**Strategic Infrastructure and
Planning
County Hall
New Road
Oxford
OX1 1ND**

19th May 2021

**Re: APP/C3105/W/21/3270400 - Land North East Of Fringford Study Centre
Adjoining, Rectory Lane, Fringford**

Figure 8
1880 Ordnance Survey Map

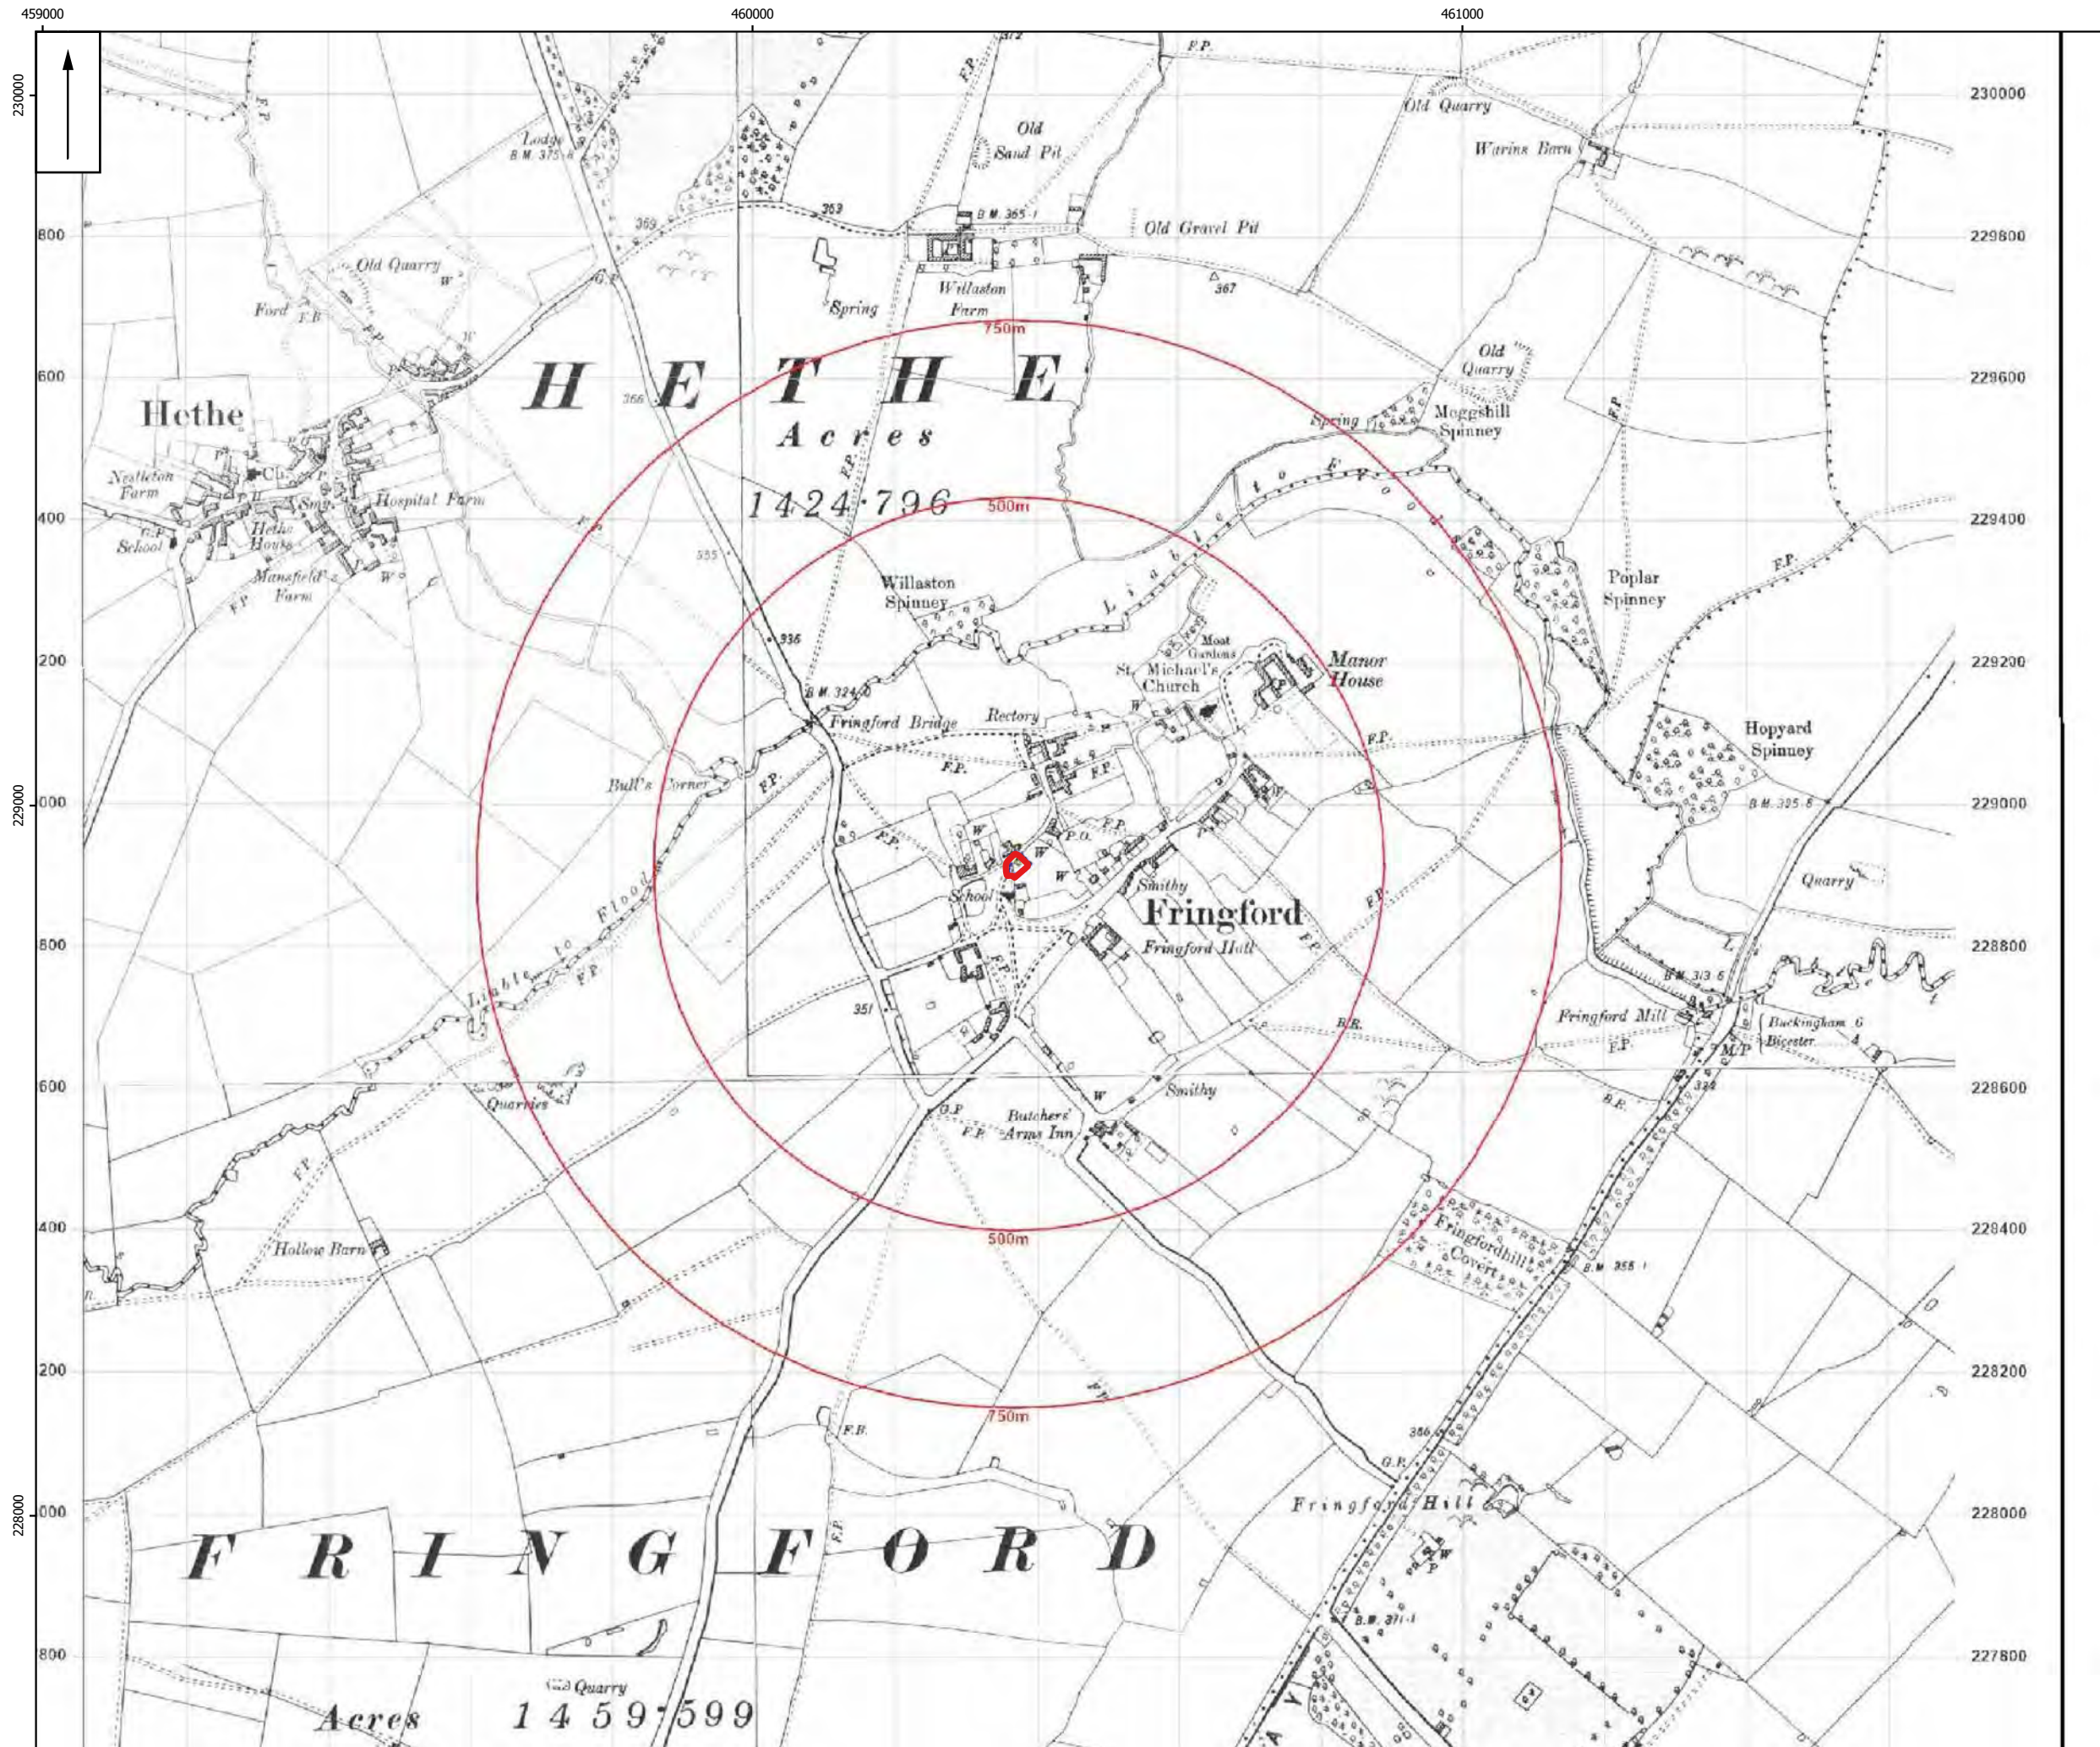
The assessment states that the site has been subject to some disturbance from a C19th building on the site identified from the 1881 OS Map and it also includes a small image showing a modern aerial photograph overlain with a map described as 1891. No building appears to be visible on this map however. The first edition OS map of 1881 does show a tree on the site which is shown outside of the footprint of this proposal. This 1881 OS map does appear to be one shown in the report.

This tree is shown as a roughly circular amorphous shape and this icon is also used elsewhere on this edition of the OS maps to denote trees. This tree is also shown on the second edition OS map (1900) in the same location using a more traditional tree icon. We have no records on early OS maps of any building on this site and there is nothing included in this assessment that demonstrates any C19th building on the site. A 1961 aerial photograph does show a number of trees in this area of the proposed site.
